PLANNING APPLICATION CONSULTATION RESPONSE

Application Number:	3/2023/0812
Proposal:	Approval of details reserved by conditions 5 (surface water drainage), 6 (construction drainage plan), 7 (surface water operation and maintenance manual), 10 (construction method statement), 13 (travel plan), 19 (pedestrian link), 20 (bird and bat boxes and hedgehog features) and 24 (external materials) of planning permission 3/2023/0153.
Location:	Old Row Whalley Road Barrow BB7 9AZ

Lead Local Flood Authority Position

File location: L:\001_DBS LIVE\WIGAN\82667 - LAND BEAR OF OLD ROW, WHALLEY RD, BARROW LNT CONSTRUCTION\GRAPHIC\FRANTCH ENGINEERING LTD - DESIGN INFORMATION\FRANTCH ENGINEERING LTD - 10-08 HYDROBRAKE DETAIL.DWG

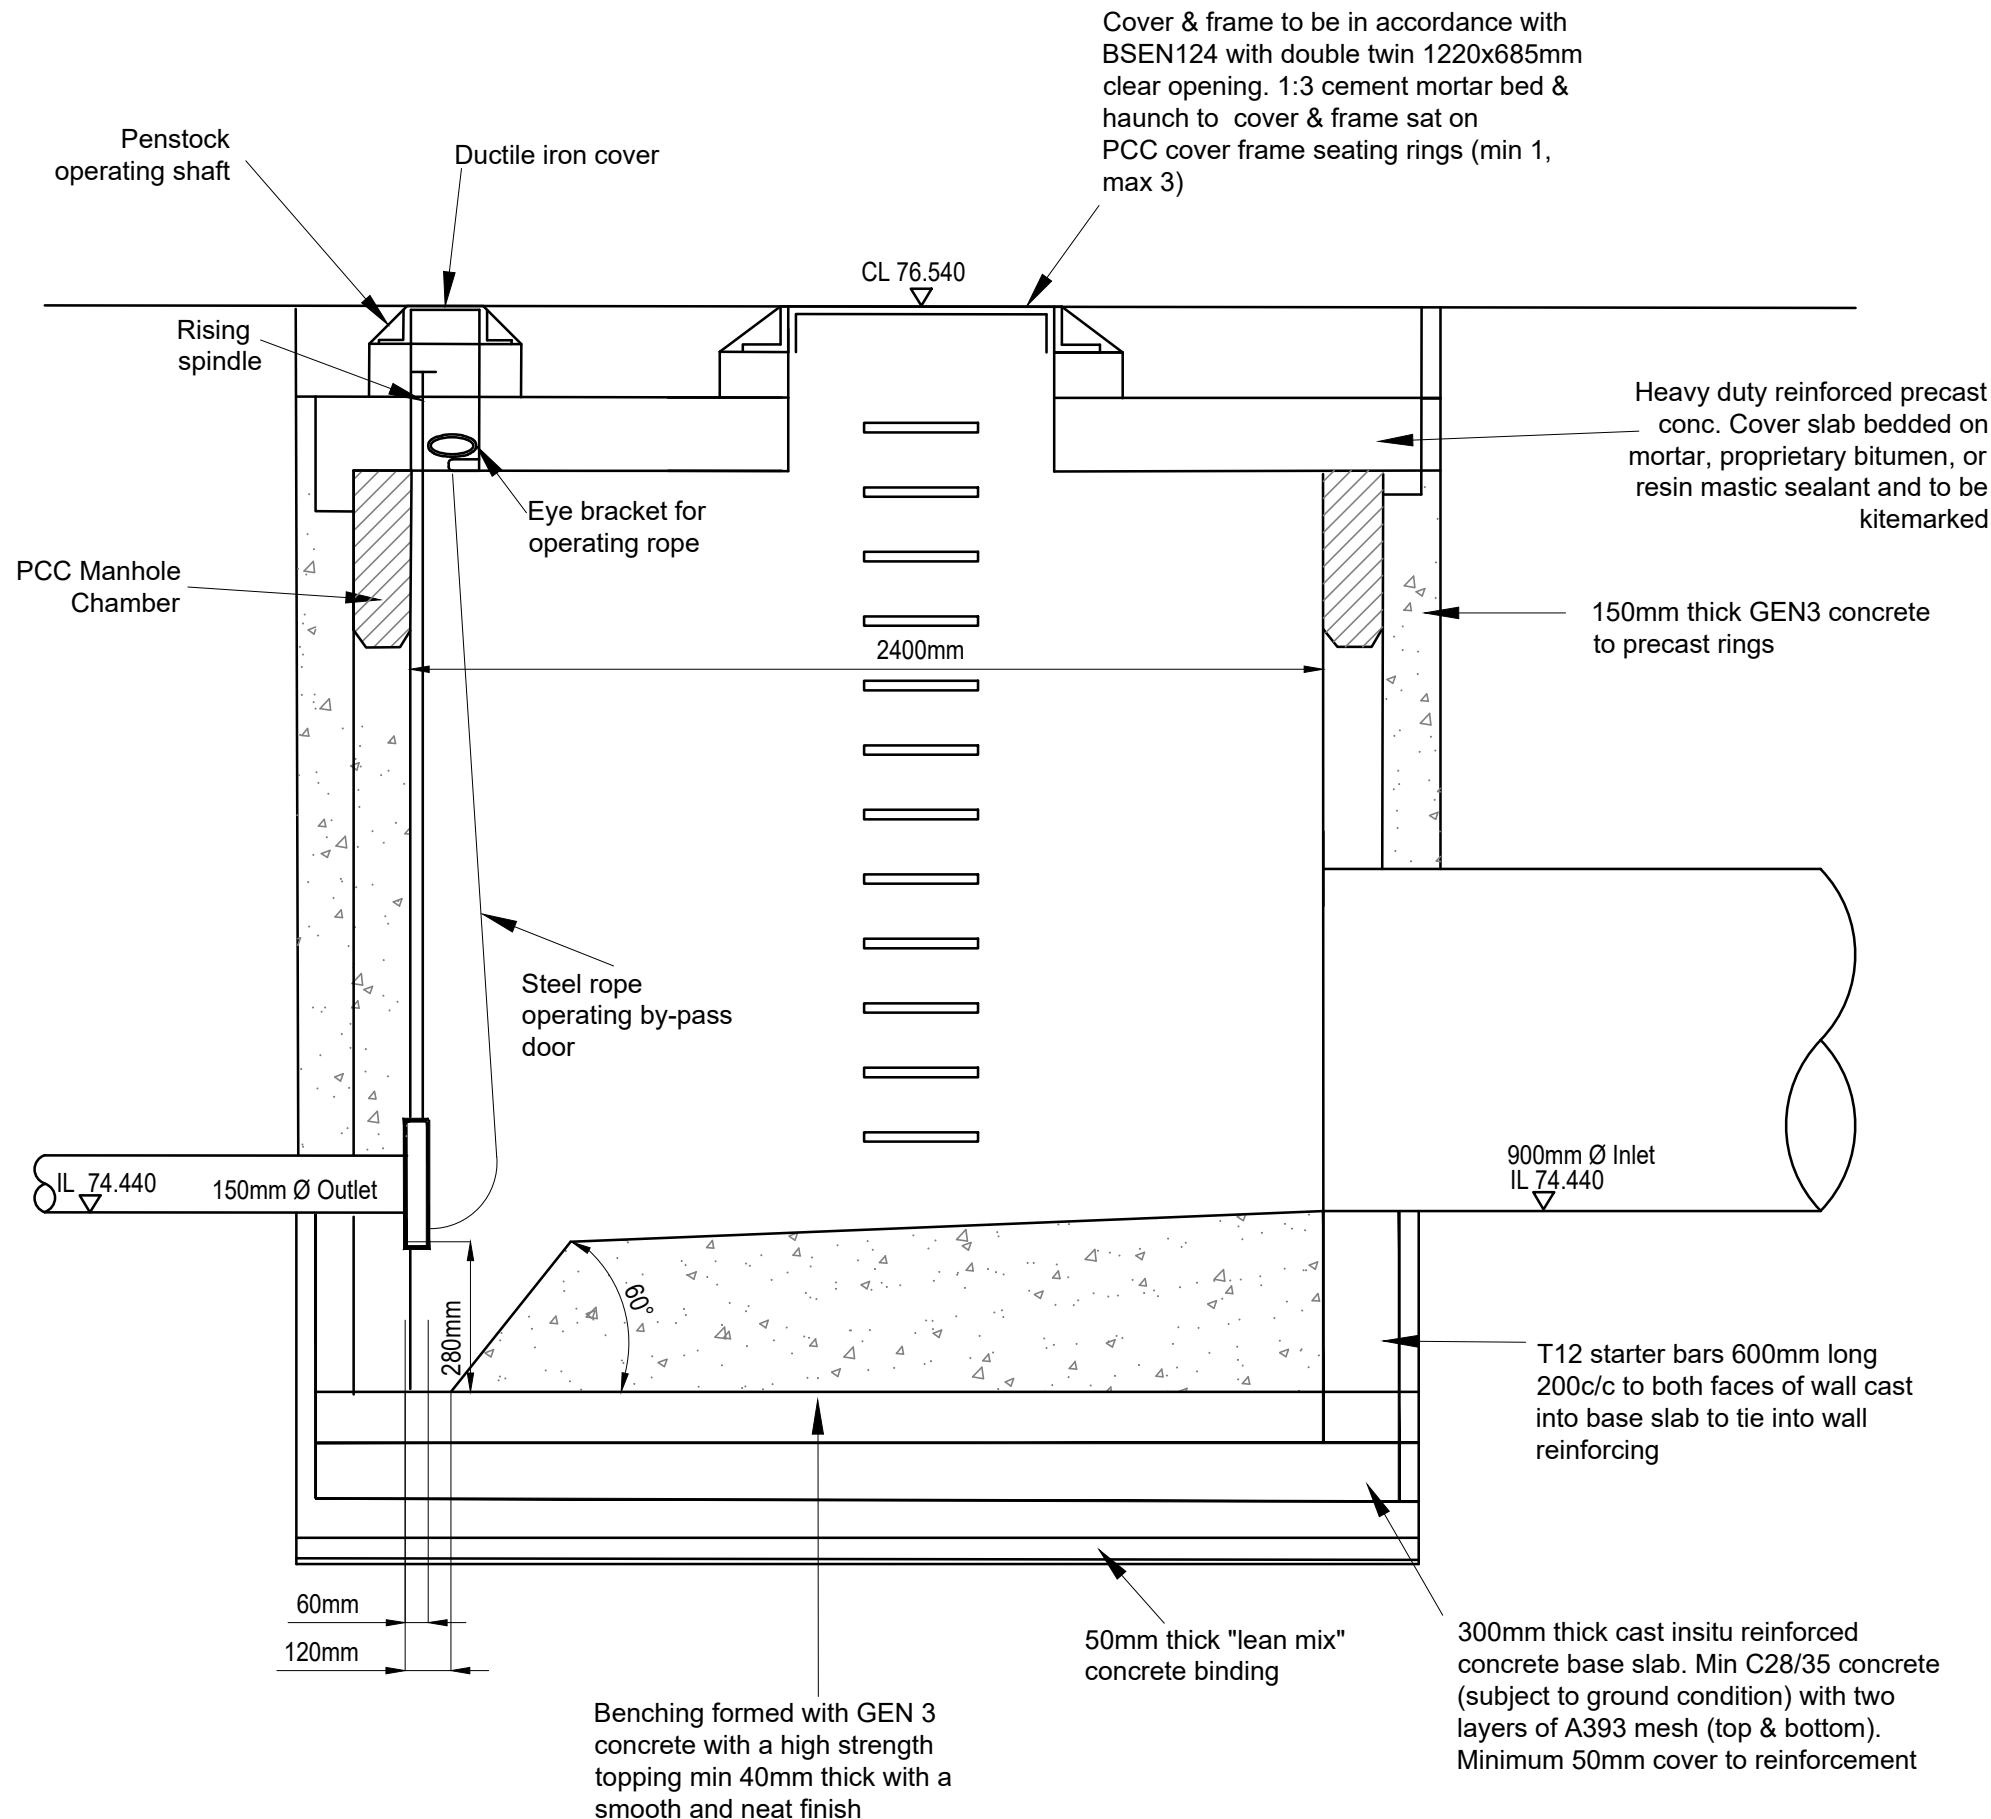
- The applicant has failed to provide evidence that a free-flowing outfall can be achieved. If this is not possible, evidence of a surcharged outfall applied to the sustainable drainage calculations will be required.
- The applicant has failed to provide evidence of an assessment of the site conditions to include site investigation and test results to confirm infiltrations rates and groundwater levels in accordance with BRE 365.
- The applicant has failed to provide evidence of an agreement in principle with the third party asset owner to connect to the off-site combined sewer.

The applicant should ensure that appropriate management and maintenance is provided, specifically in regard to the flow control device and its discharging at 2l/s.

Impermeable Area Plan

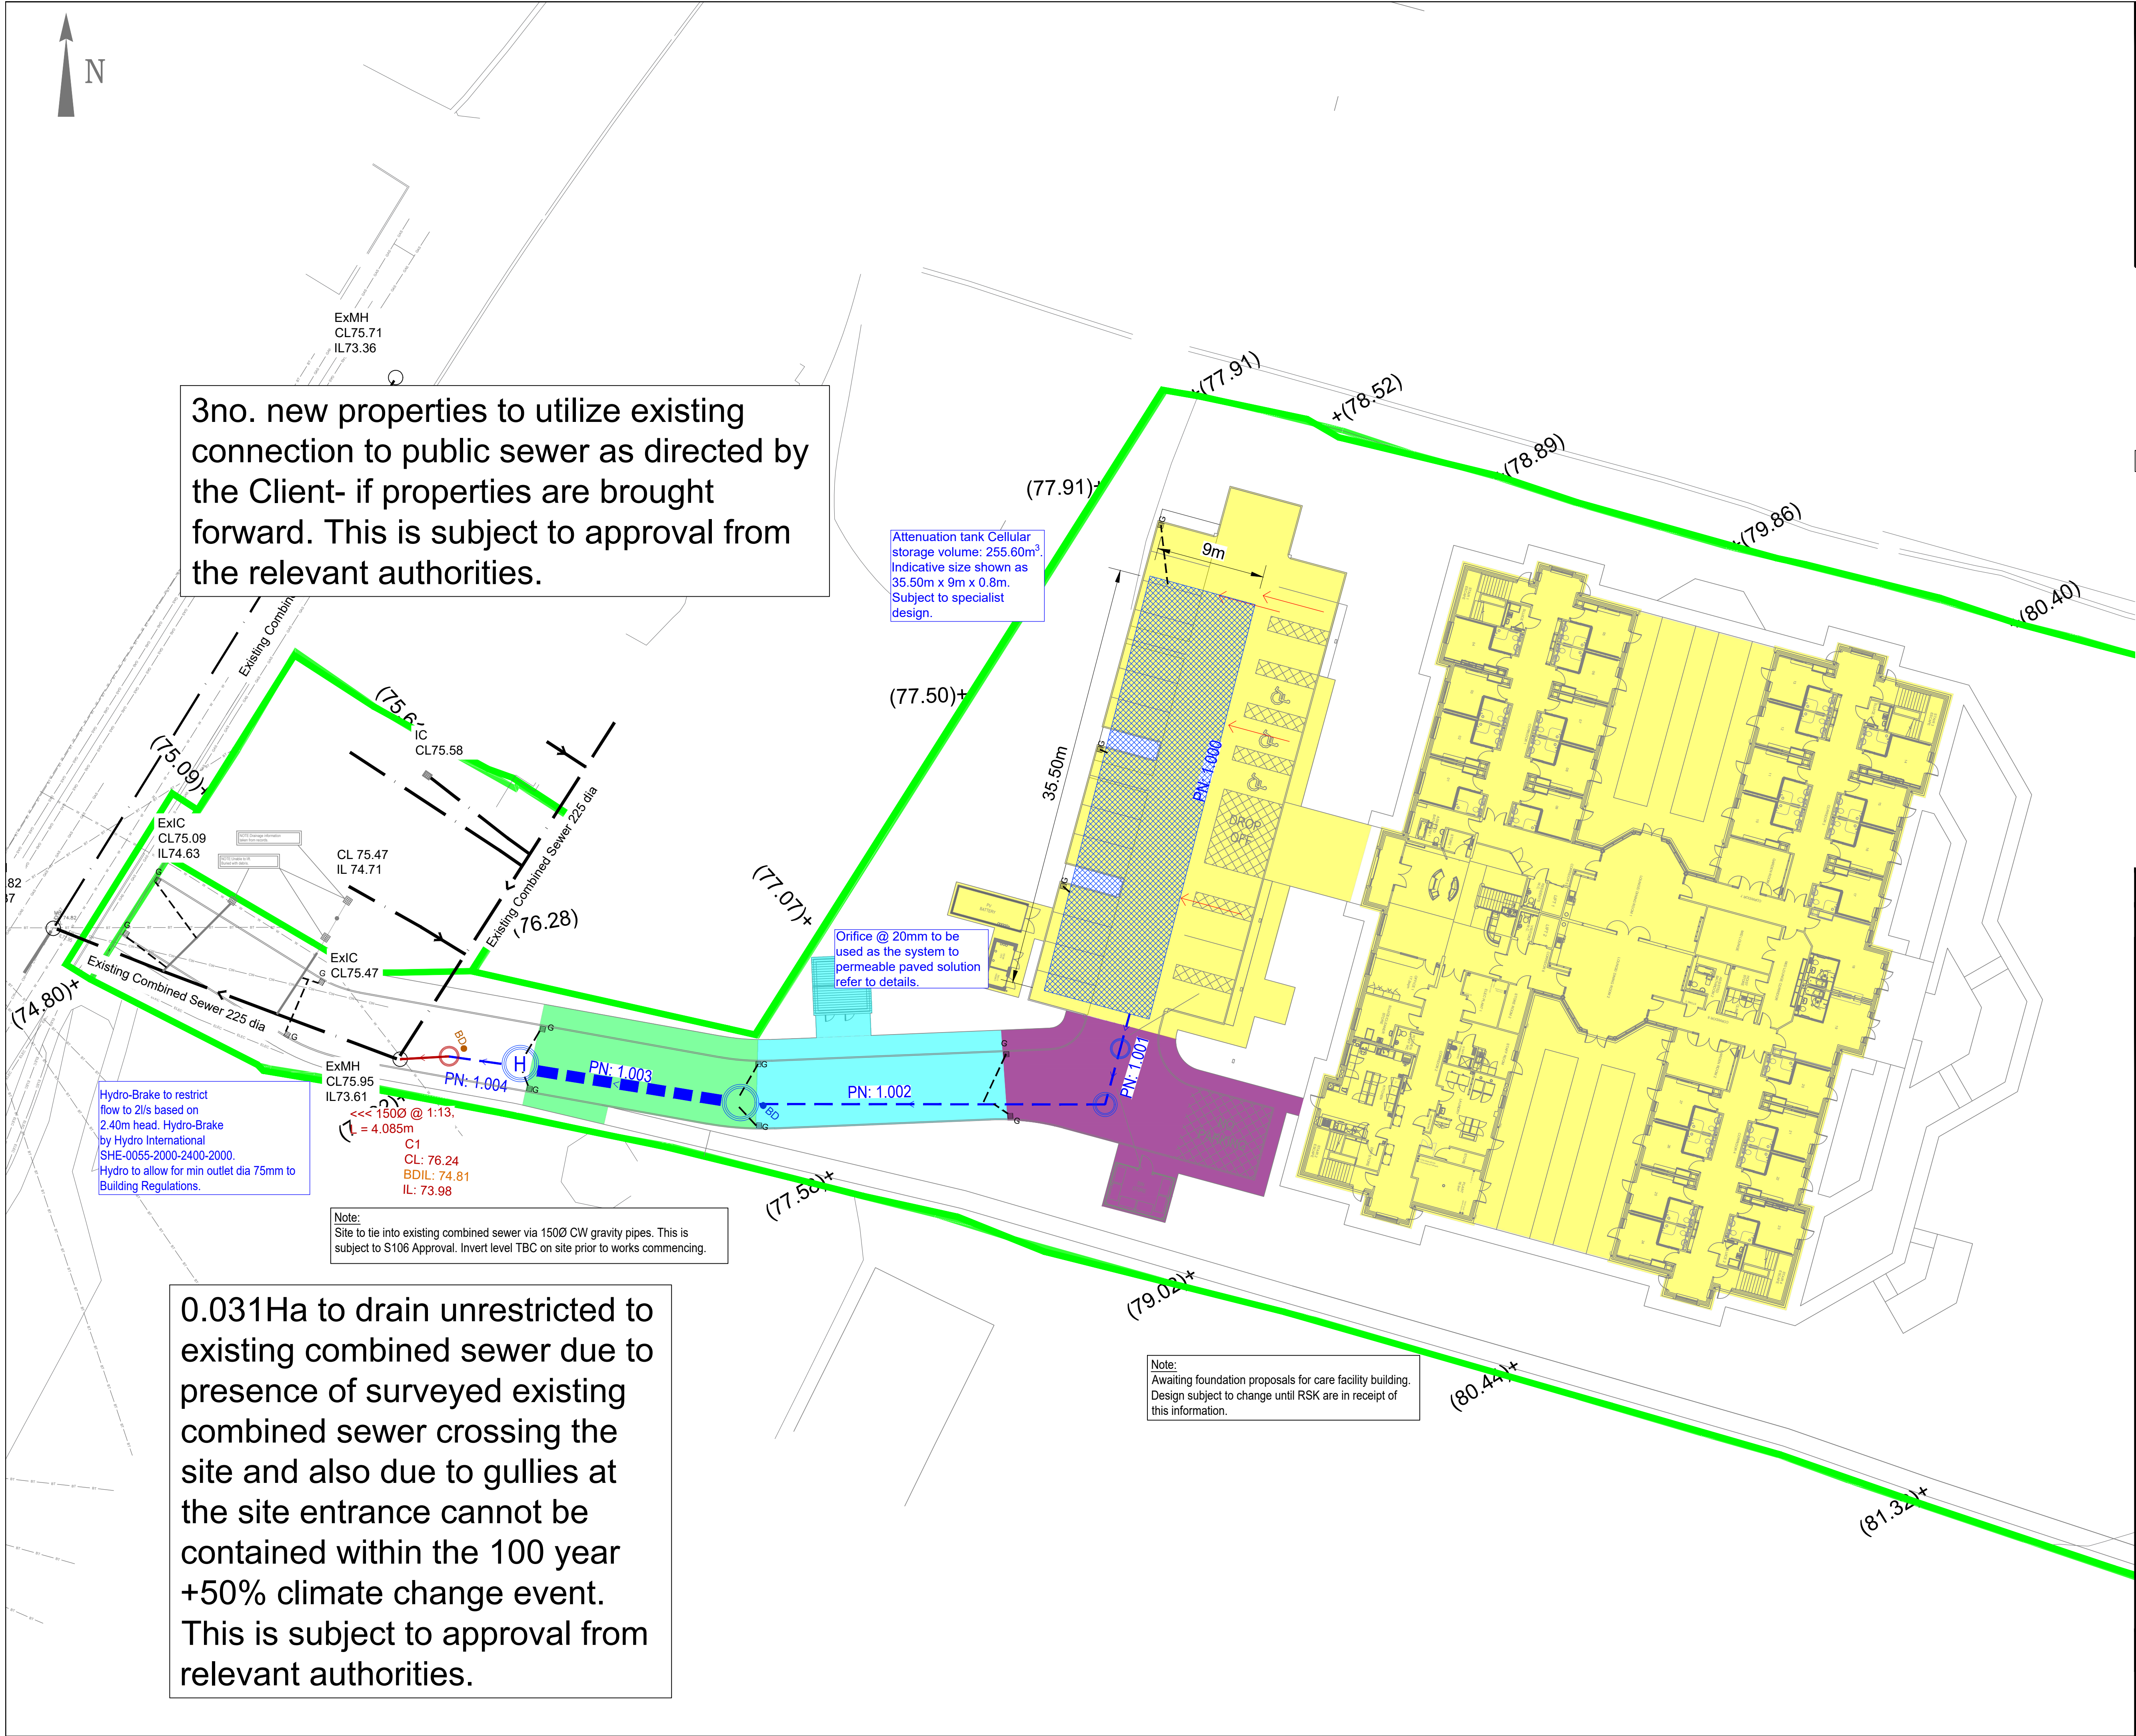
- The applicant has failed to provide evidence of the drainage calculations, along with evidence for an allowance for climate change and urban creep.
- The applicant has failed to provide the appropriate climate change allowance, as specified in the condition.
